Application H03-0628-18
Location Littleworth Drove Deeping St Nicholas Spalding PE11 3ET
Proposal Residential development - re-submission of H03-0366-17

Name Glen Chapman
Address Environmental Services South Holland District Council

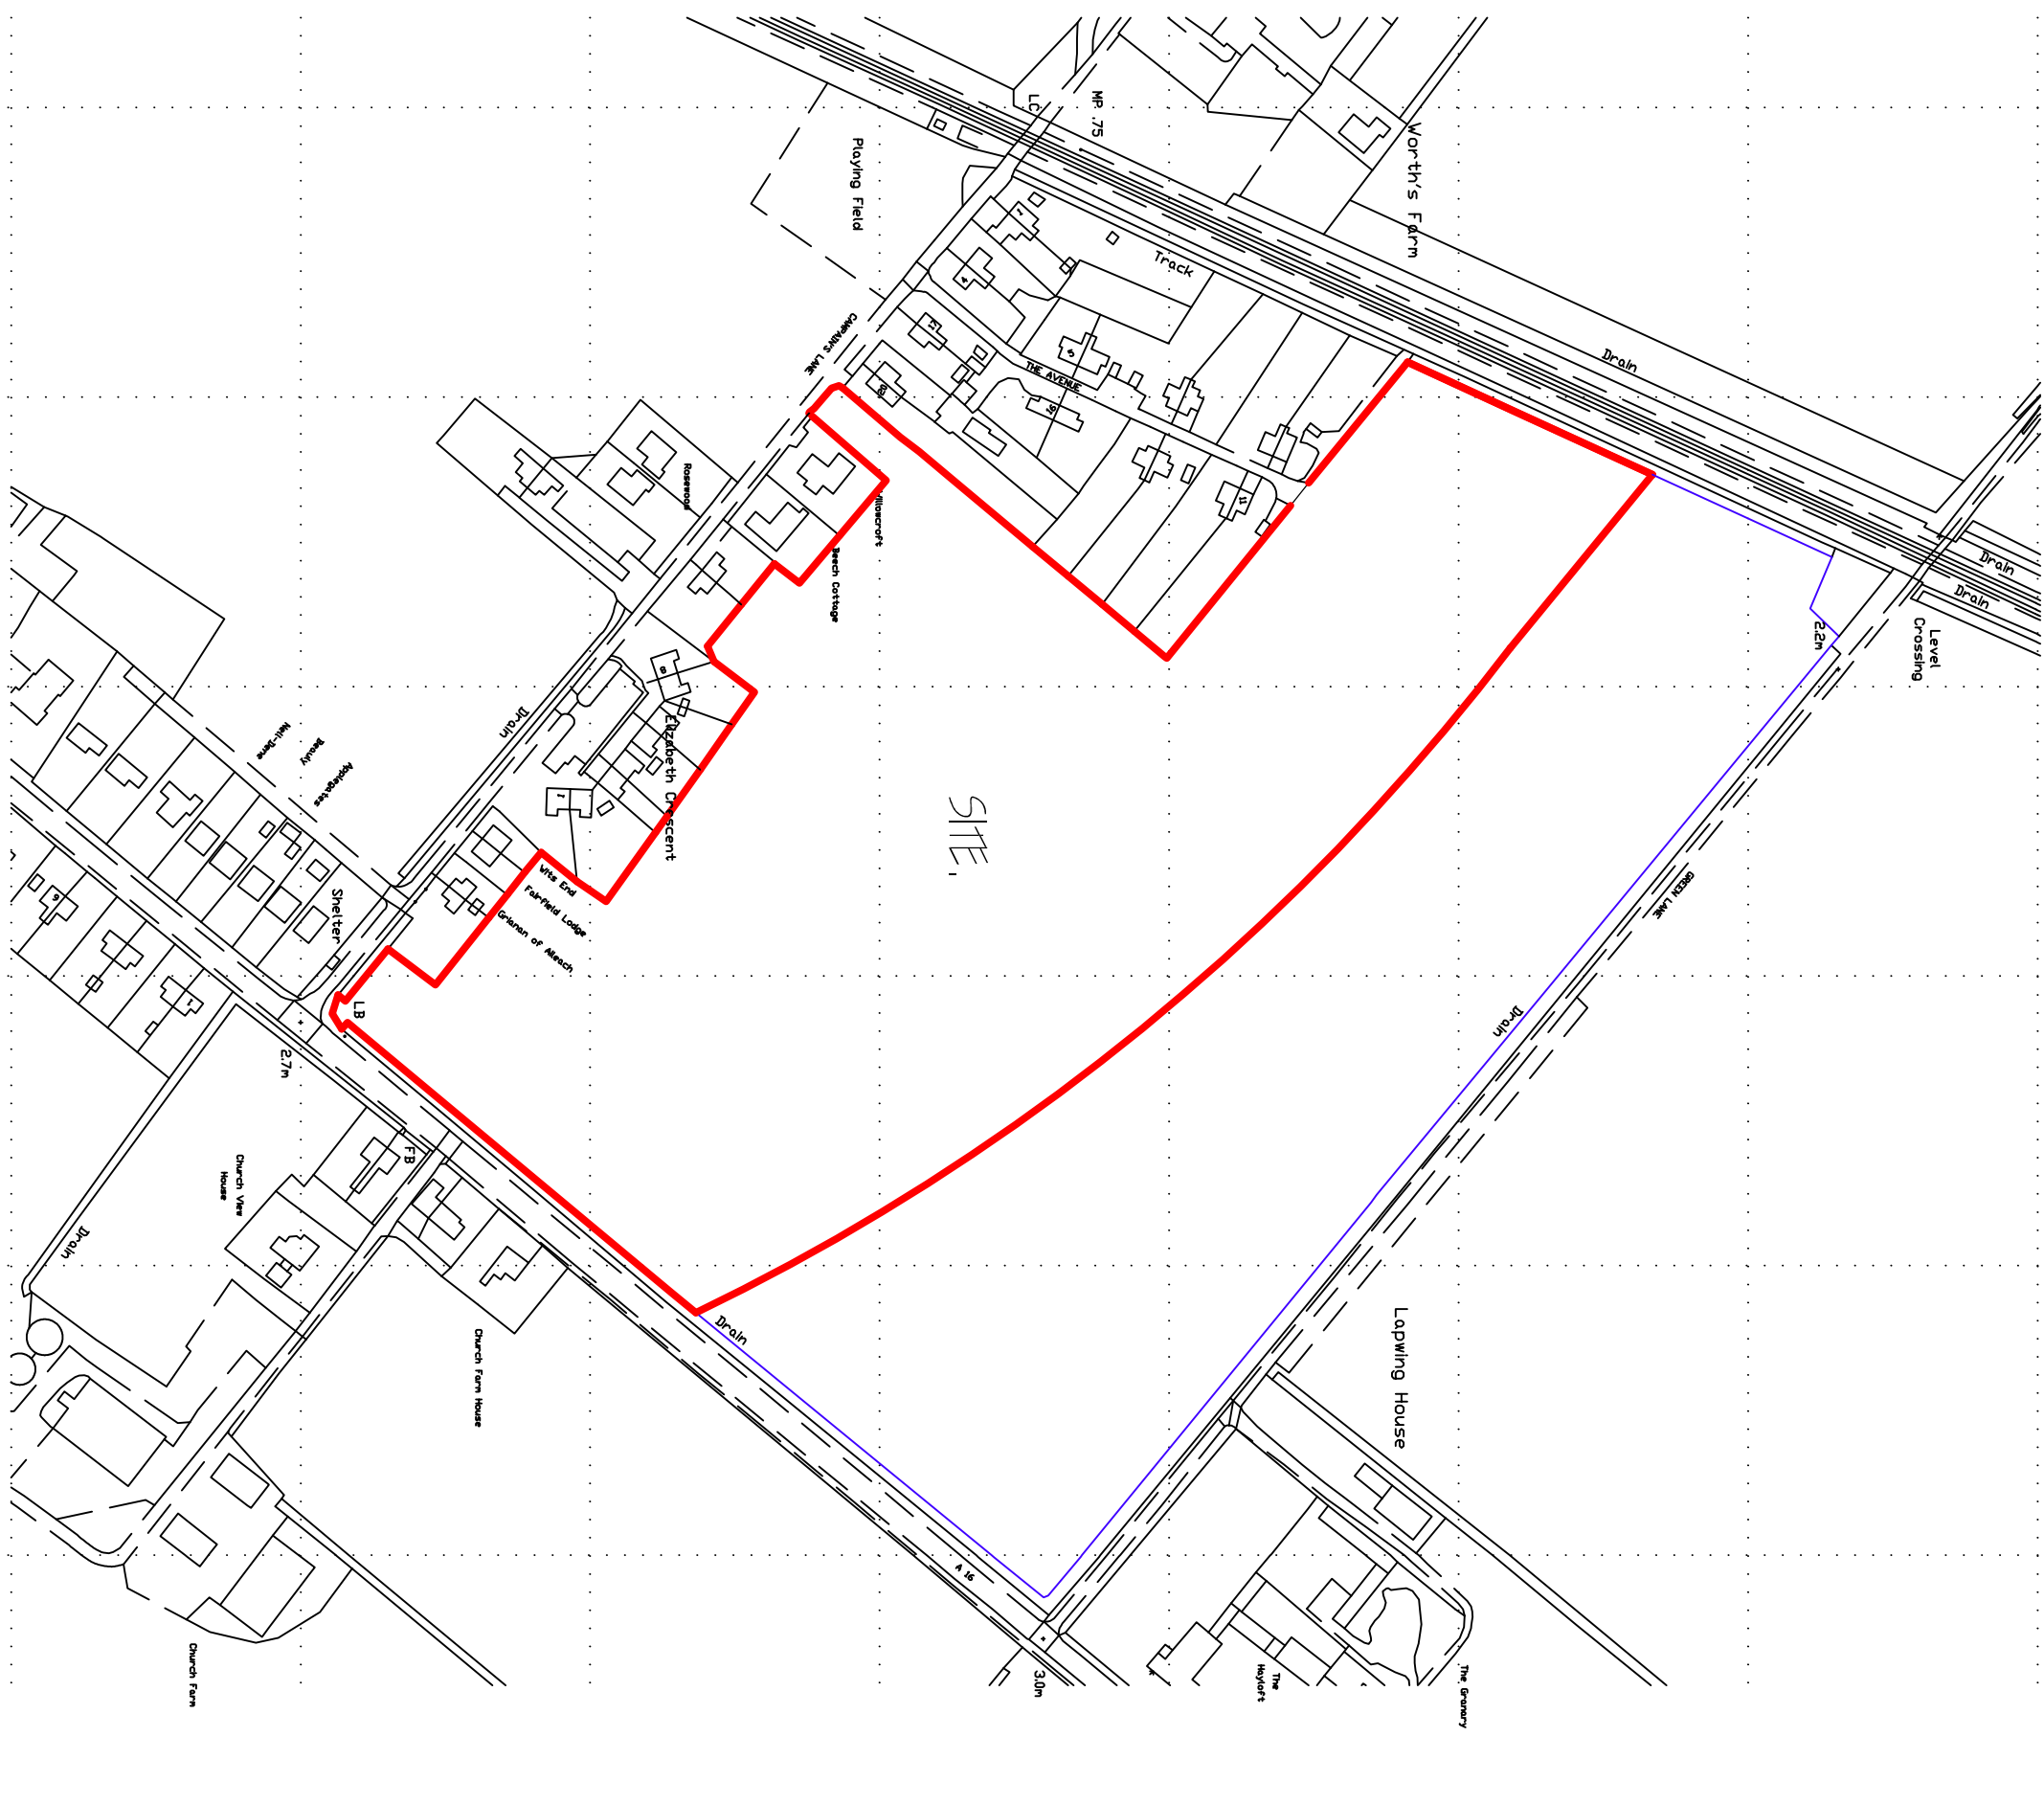
As all access roadways to all residential properties appear to be constructed to an adoptable standard under an agreement with Lincolnshire County Council so that they will become public highways this will enable refuse/recycling collections to be carried out from outside individual properties without the need for communal collection points. This is very much our preferred option for new developments.
